Planning Application Ref: FP/257/17/T

Location : Open Space bordered by Copeland Road and The Ridgeway and Minton Road, Felpham

Description of works: Various works to trees on the green.

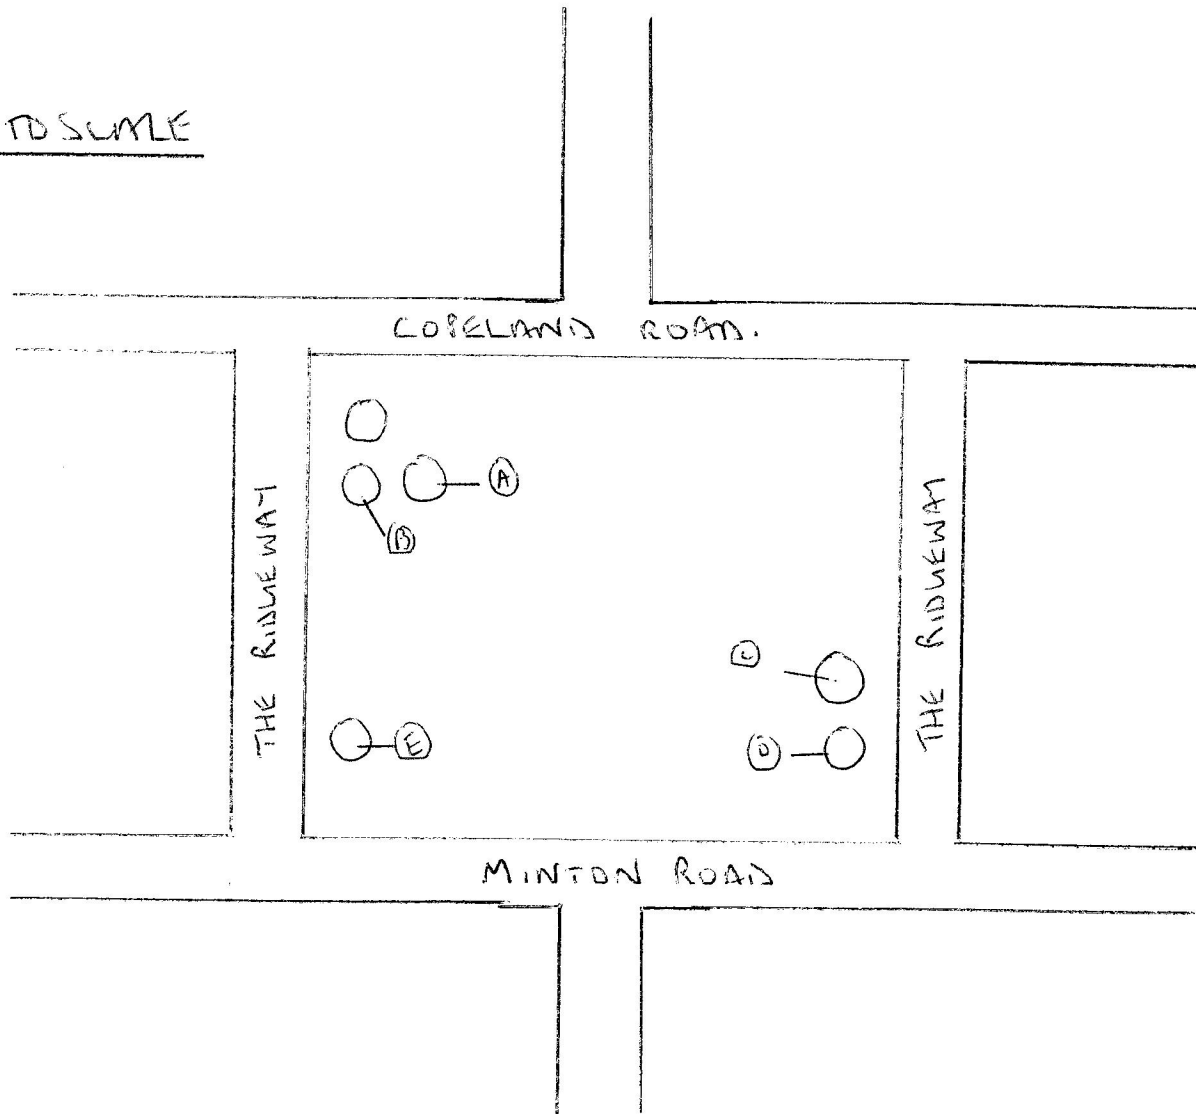
A Grey Poplar *Populus canescens* - a small tree and removing 4m would leave just a trunk devoid of foliage totally undermining its value in the landscape and contrary to BS3998 recommendations.

B Holm Oak *Quercus ilex* - the low overhang of the road is a danger and must be dealt with.

C Horse Chestnut *Aesculus hippocastanum* - in a state of terminal decline.

D Pines *Pinus spp.* - do contain a lot of dead branches

A **Grey Poplar** - reduction by 4m in height and 2m in spread.

B Holm Oak trim back the lateral branches on the west side ONLY to clear back from the road –

C **Horse Chestnut** - fell and grub out the stump and plant a replacement tree – to be one of the following :

- Once the Chestnut tree has been removed in a safe and controlled manner and the stump and primary root runs ground or grubbed out a replacement tree is to be planted in its place.
- This is to be of **Standard Nursery Stock** – a tree of 8ft to 10ft in height and 8cm to 10cm in circumference staked and tied on a short staking system planted within 12 months of the original trees removal.
- It is to be one of the following species:-

D **Pines** - permission is not required to remove deadwood.

1. ***Reduce in height by 2m***
2. ***Reduce lateral spread by 1m.***
